Ribble Valley Borough Council
Housing & Development Control

Your ref: 3/2023/0137
Our ref: D3.2023.0137
Date: 16th March 2023

Application no: **3/2023/0137**

Proposal: **Proposed demolition of existing conservatory and detached garage.
Construction of single storey side and rear extension.**

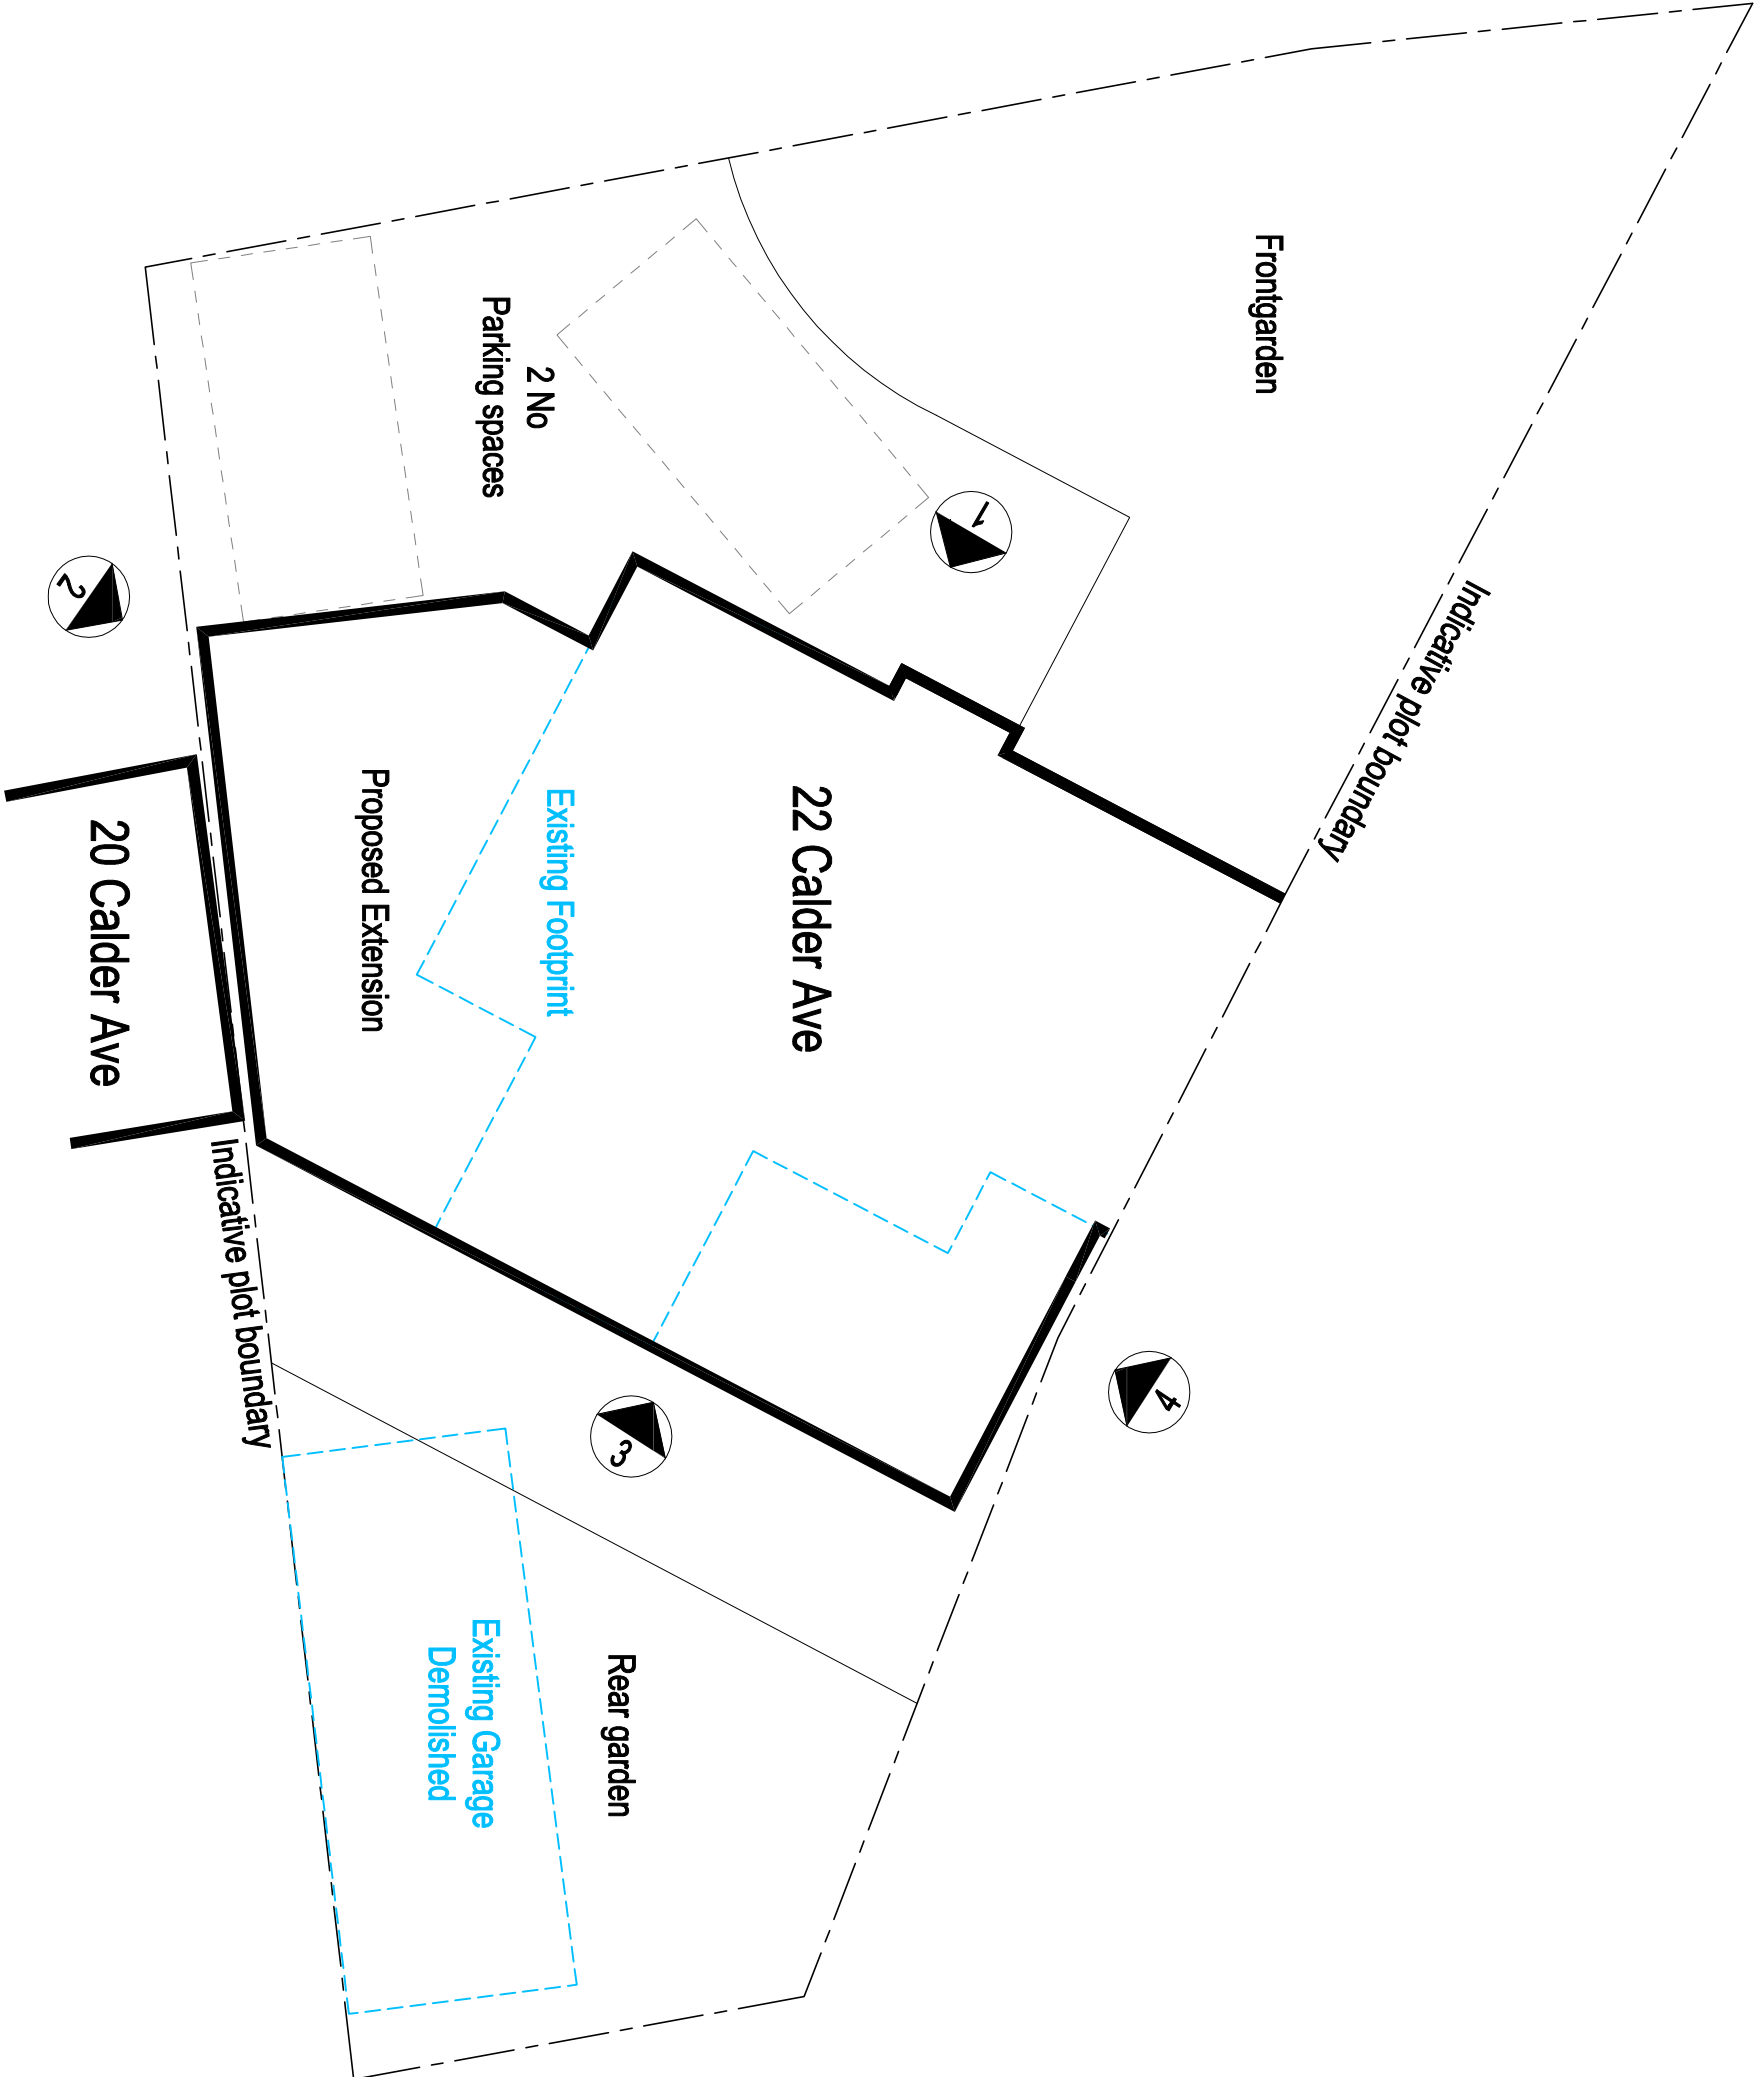
The LHA have reviewed AW+A drawing number PL/05 Rev A titled "Proposed Site Block Plan" and are aware that the access will be extended to provide two car parking spaces on the existing driveway following the proposal.

The LHA have no objection to the widening of the access but advise the Applicant that a dropped kerb application will be required and that the existing streetlight, adjacent to the existing access, will need to be relocated as part of the application. The relocation will be at the full cost of the Applicant.

The LHA have reviewed AW+A drawing number PL/05 Rev A titled "Proposed Site Block Plan" and are aware that the site will provide 2 car parking spaces for the proposed 2 bed dwelling which complies with the LHAs parking guidance as defined in the Joint Lancashire Structure Plan. Therefore, the LHA have no objection to the proposal.

1. No part of the development hereby permitted shall be occupied until such time as the access arrangements shown on AW+A drawing number PL/05 Rev A have been implemented in full.

2. The development hereby permitted shall not be occupied until such time as the parking and turning facilities have been implemented in accordance with AW+A drawing number PL/05 Rev A. Thereafter the onsite parking provision shall be so maintained in perpetuity.
